## Rivenhall IWMF and Energy Centre – EN010138

### Section 51 advice regarding draft application documents submitted by Indaver Rivenhall Ltd

On 6 September 2023, Indaver Rivenhall Ltd submitted the following draft documents for review by the Planning Inspectorate as part of its Pre-application Service<sup>1</sup>:

Figure 3.2: Inlet Control Valve Arrangement

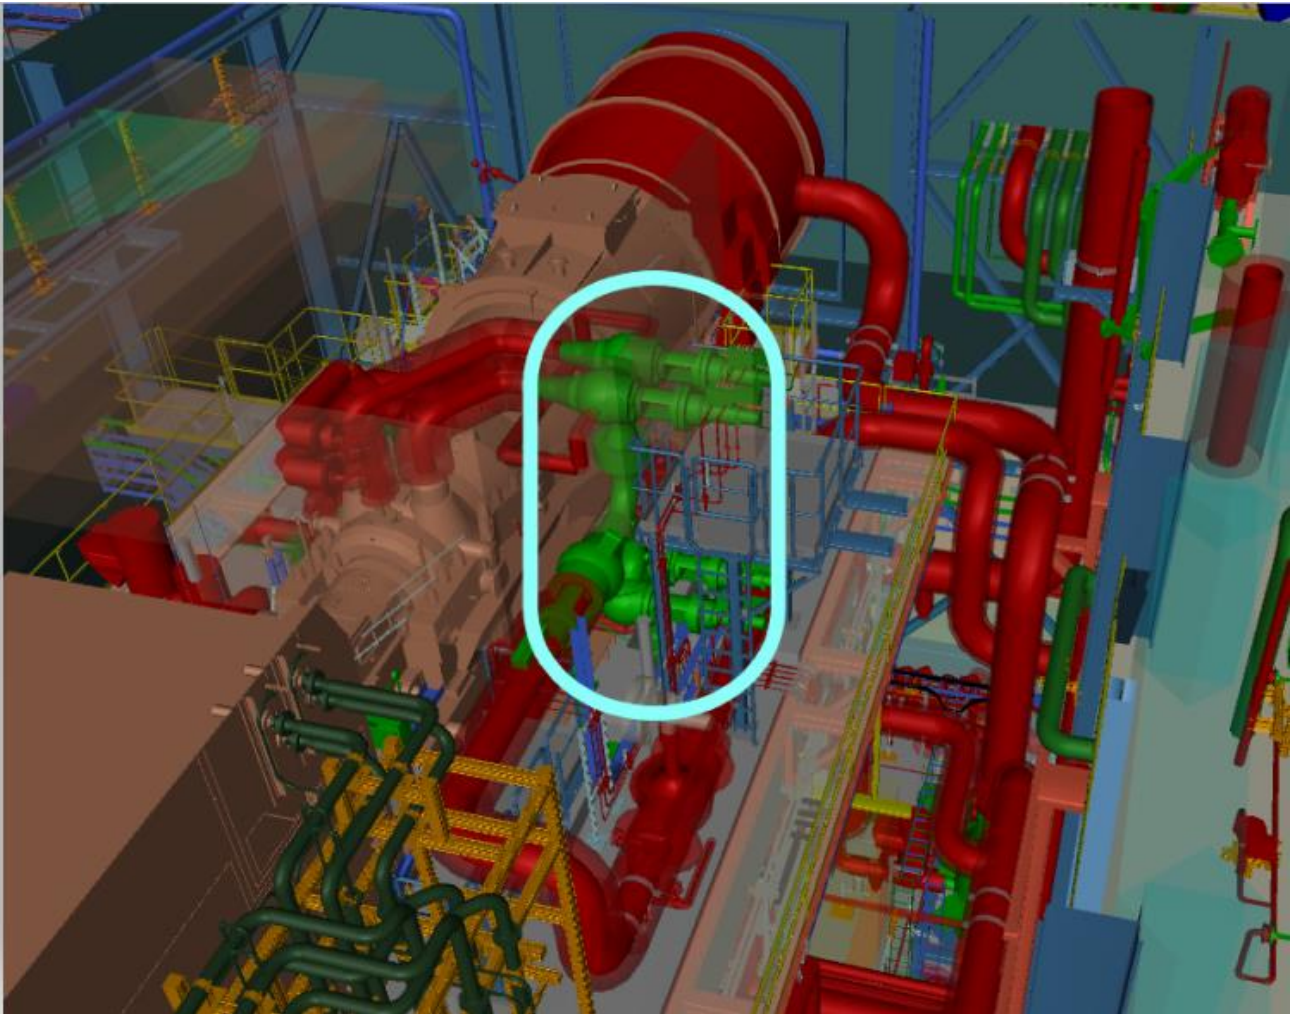
Environmental Statement - Proposed Development Chapter		
Ref No.	Paragraph/Section	Comment/Question
	3.4.2	In respect of Works No 2. Are there any implications if the work is carried out in the factory or in an on-site workshop?
